Dáta | Date
9 December, 2024

Ár dTag | Our Ref.
TII24-129221

Re. Strategic Infrastructure Development – 10 year planning permission for a wind energy development consisting of 17 no. wind turbines and related works on land at Cummeennabuddoge, Clydaghroe, Glashacormick and Cummeenavrick (County Kerry), and Caherdowney (County Cork)

ABP Case ref. PA08.321029

Figure 7-2
Abnormal Loads Route

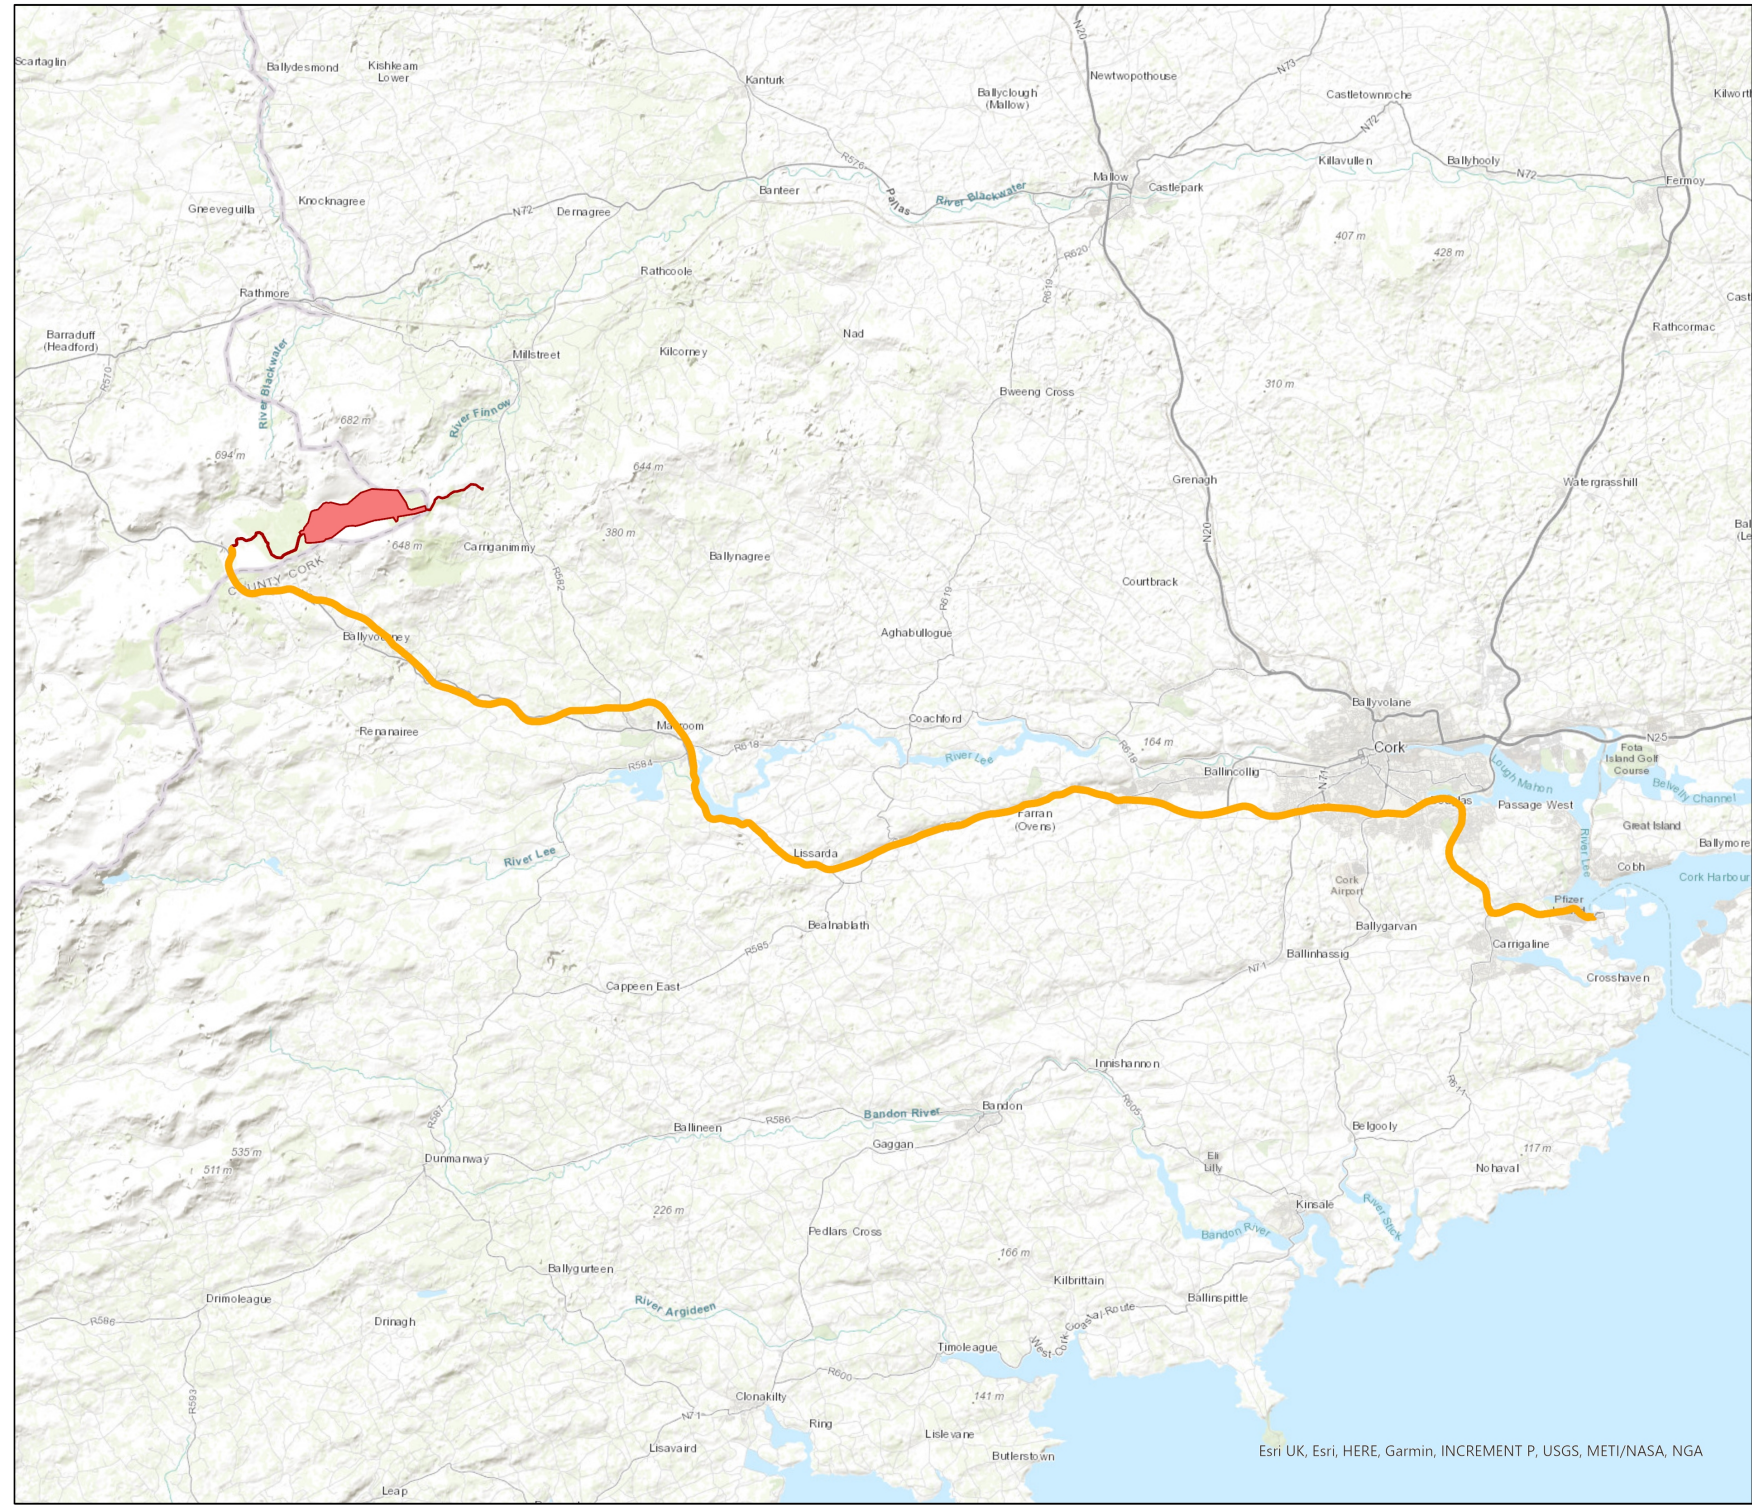
The proposed haul route for turbine component delivery to site is outlined in Section 1.4.2 of the EIAR as being from Ringaskiddy Port to site utilising the N28, N40 and N22, national roads, and then onto the local road to the site entrance. Appendix 7-1 includes a 'Preliminary Route Assessment' of the turbine components and outlines the extent of minor works required to facilitate turbine component delivery to site. It is noted that measures are proposed which impact all national roads concerned.

The proposed haul route is within Counties Cork and Kerry, the applicant/developer should therefore consult with each County Council. In addition, the national road network is managed by a combination of PPP Concessions, Motorway Maintenance and Renewal Contracts (MMaRC) as well as the local road authorities. The applicant/developer should consult with all PPP Companies, MMaRC Contractors as well as the road authorities

over which the haul routes traverse to ascertain any operational requirements such as delivery timetabling, etc. and to ensure that the strategic function of the national road network is maintained.

In the interests of clarification, any proposed works to the national road network to facilitate turbine component delivery to site shall comply with TII Publications and shall be subject to Road Safety Audit as appropriate. Works should ensure the ongoing safety for all road users and prior to any development necessary licenses, approvals or agreements with the local road authorities shall be in place.

As noted above, Haul Route proposals for wind turbine component delivery to site are outlined in Section 1.4.2 and Appendix 7-1. It is unclear if delivery of turbine or substation components to site might include for the potential of any abnormal 'weight' load.

With specific reference to national road structures on the proposed haul route, all structures should be checked by the applicant/developer to confirm that all the structures can accommodate the proposed loading associated with the delivery of turbine and/or substation components where the weight of the delivery vehicle and load exceeds that permissible under the Road Traffic Regulations.

The Authority considers that it is critical a full assessment by the applicant/developer of all structures on the national road network along the haul route should be undertaken, where relevant, and all road authorities along the haul routes should confirm their acceptance of proposals by the applicant. Specific requirements for any 'Exceptional Abnormal Loads' should also be considered and addressed where required in accordance with TII Publications.
